Appeal Decision

Appeal Ref: 6002507

210 Whitehall Road East, Birkenshaw, Bradford BD11 2LL

- The appeal is made under section 78 of the Town and Country Planning Act 1990 (as amended) against a refusal to grant planning permission.
 - The appeal is made by Mr R Halloran against the decision of Kirklees Council.
 - The application reference is 2025/62/92279/E.
 - The development proposed is demolition of existing dwelling and erection of new dwelling.
-

drawing PROPOSED PLANS AND ELEVATIONS

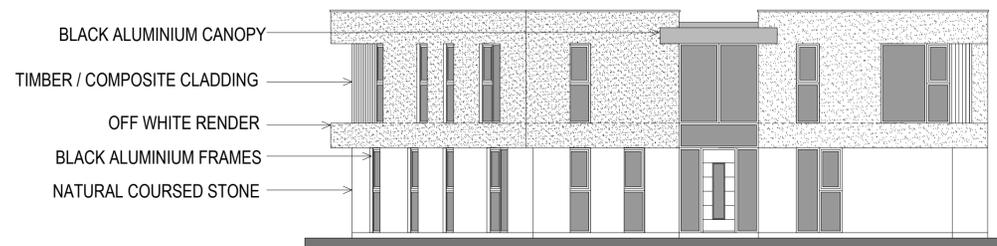
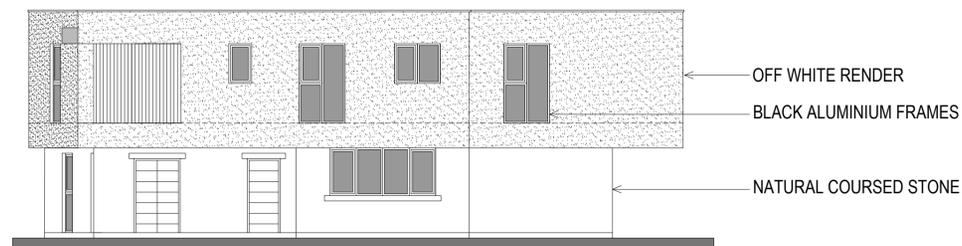
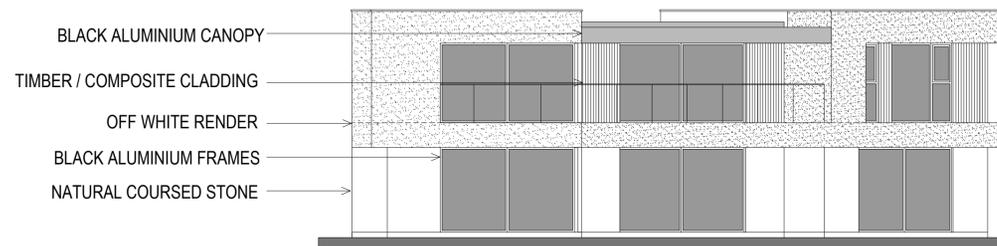
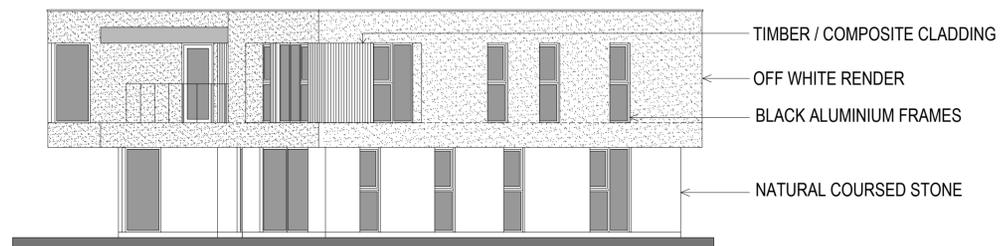
6. The proposed replacement dwelling would sit parallel to the highway and closer to it than the existing dwelling. Whilst it would be further from the western boundary, its significantly greater depth would create a much bulkier and more dominant building when viewed from the west. The traditional materials, pitched roof and simple rectangular form allow the existing dwelling to sit comfortably in the

landscape, particularly when seen against the backdrop of traditional stone buildings to the east. In contrast, the proposed dwelling's increased massing, footprint and flat-roofed contemporary design would appear incongruous and visually intrusive. Whilst there are limited buildings in the vicinity of the site, outside the built-up areas, there is clearly a strong tradition of stone buildings with pitched roofs within the landscape, including those to the east and at Hill Top Farm to the north.

7. The use of off-white render at the upper floor level and the extensive glazing, especially on the western elevation, would make the building even more conspicuous. The design would also create an unusual top-heavy appearance. Although the flat roof would reduce the overall height compared with a pitched roof, the building would still be substantial in scale and would not respond positively to its surroundings or integrate well into the landscape. The proposed garage, although smaller, would also appear dominant and intrusive due to its elevated position above the highway and its location close to the northern boundary.
